TOWN AND COUNTRY PLANNING ACT 1990

OUTLINE

Reference:	H23-0731-23	Date of Decision:	3rd October 2023
Applicant:	Mr & Mrs I Sloan Victoria Cottage Stockwell Gate North Whaplode Spalding PE12 6WH		
Location:	Adj Victoria Cottage Stockwell Gate North Whaplode Spalding		
Description:	Proposed Residential Development

## Proposed Block Plan

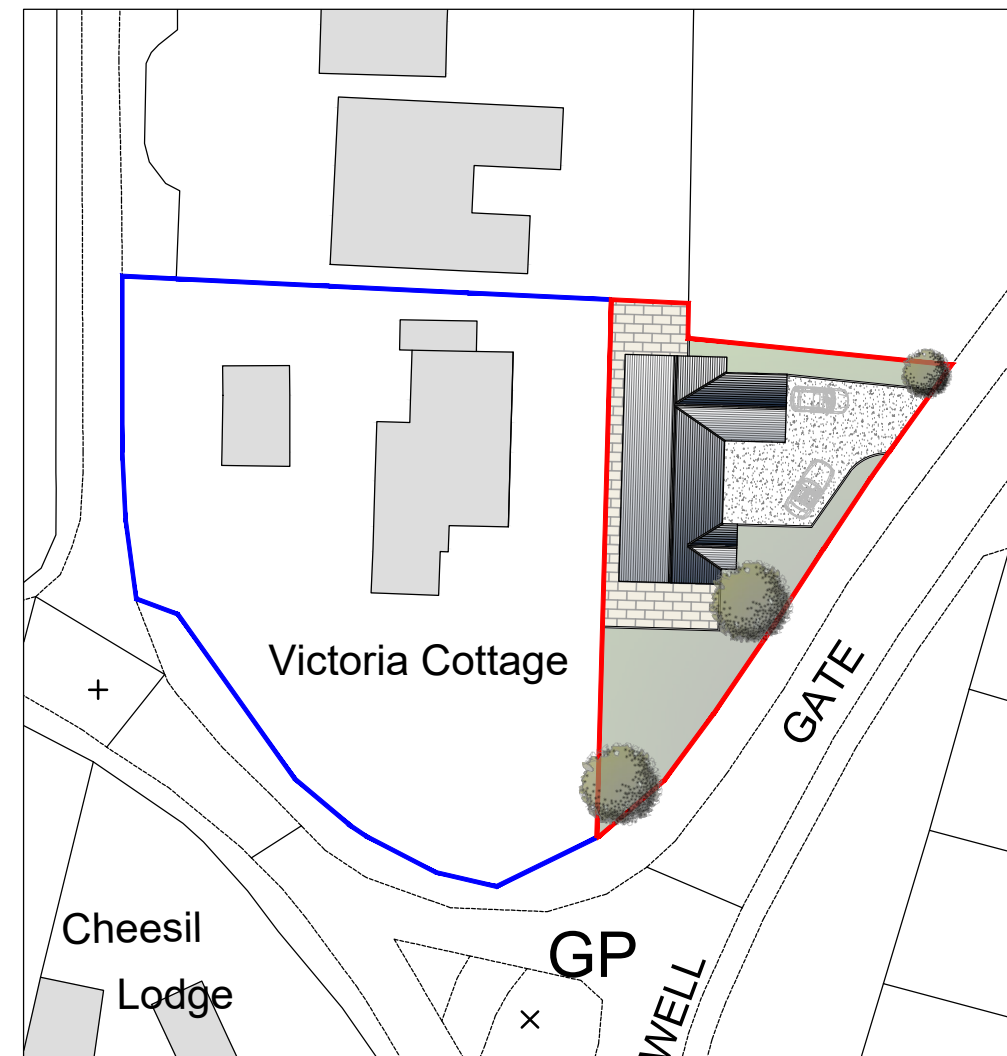
The dwelling, by virtue of its size and density when compared to the plot would result in unacceptable adverse impacts on the character and appearance of the street scene of Stockwell Gate North and would appear as a cramped form of development. Accordingly, the proposal would be contrary to Policies 2, 3 and 30 of the adopted South East Lincolnshire Local Plan (SELLP, 2019) and the guidance within the National Planning Policy Framework (NPPF, 2023) and is therefore refused.

- 2 The proposed dwelling to be built on this land would suffer greatly from a lack of amenity and privacy. The closeness and proximity between the proposed dwelling and the existing Victoria Cottage would result in the amenity spaces and windows of the proposed residential development to be significantly overlooked and therefore a real lack of privacy and loss of amenity. Likewise, the proposed dwelling, if built as a two storey, would overlook into Victoria Cottage and therefore mean they would also lose their privacy and impact the amenity further.
